**KIRKLEES METROPOLITAN COUNCIL
INVESTMENT & REGENERATION SERVICE**

DELEGATED DECISION TO DETERMINE PLANNING APPLICATIONS

Reference No: 2018/62/91866/E

Description: Demolition of existing dwelling and erection of 4 dwellings

Ouzelwell Lane - Street Elevation As Proposed
Scale 1:200
0m 5m 10m

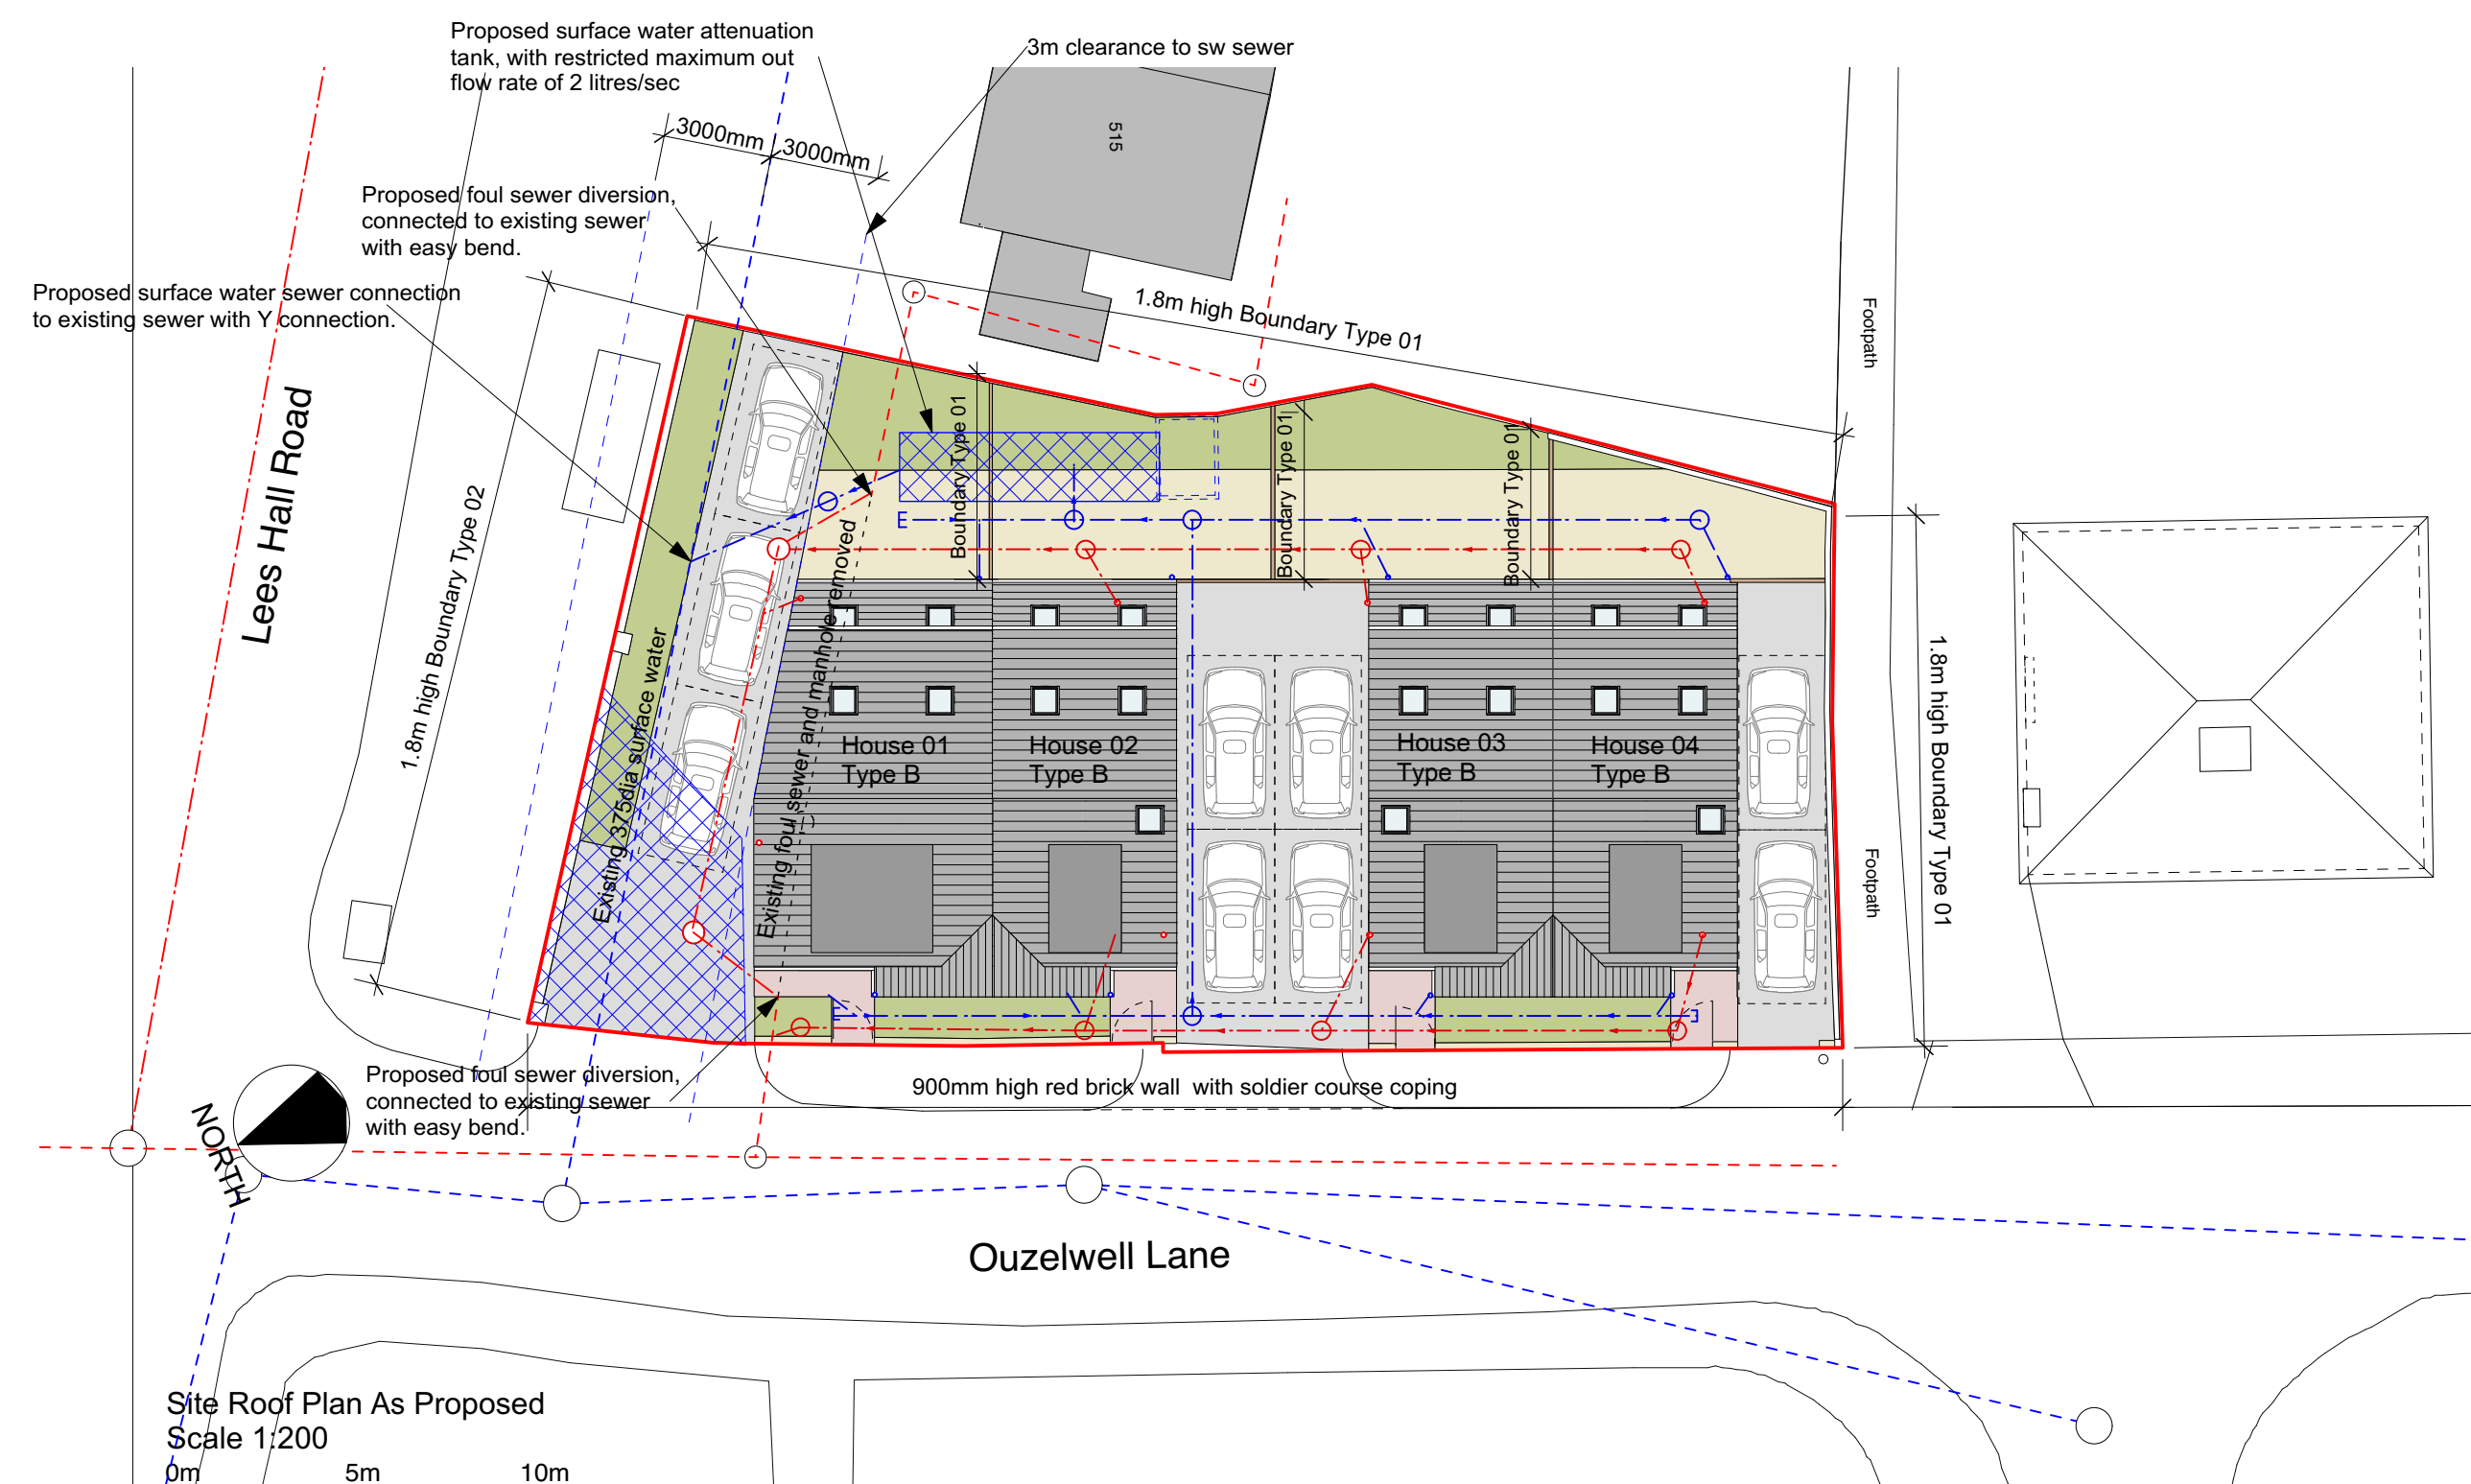
1. The proposed dwellings, by virtue of the combination of their scale and design, would result in an incongruous and cramped form of development on this prominent corner site. The proposals would therefore be harmful to visual

amenity and fail to add to the overall quality of the area and would not be visually attractive. As such, the proposals would be contrary to Policy PLP 24 (as modified) of the Kirklees Local Plan as well as the aims of Chapter 12 of the National Planning Policy Framework.

Site Roof Plan As Proposed
Scale 1:200
0m 5m 10m

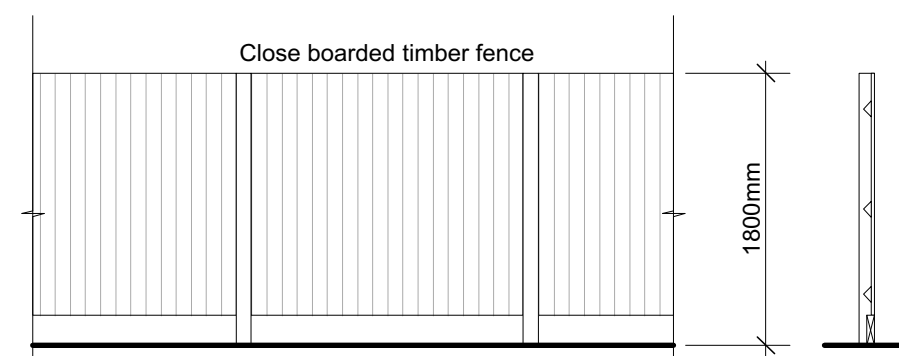
2. The proposed dwellings, due to a combination of the proximity to the rear site boundary and the scale of the dwellings, would result in the overlooking and overbearing impact on the rear elevation and rear garden area of no.515 Lees Hall Road. As such, the proposals would be harmful to residential amenity and contrary to Policy PLP 24 (as modified) of the Kirklees Local Plan as well as the aims of Chapter 12 of the National Planning Policy Framework, which seeks to, amongst other things, ensure that developments function well.
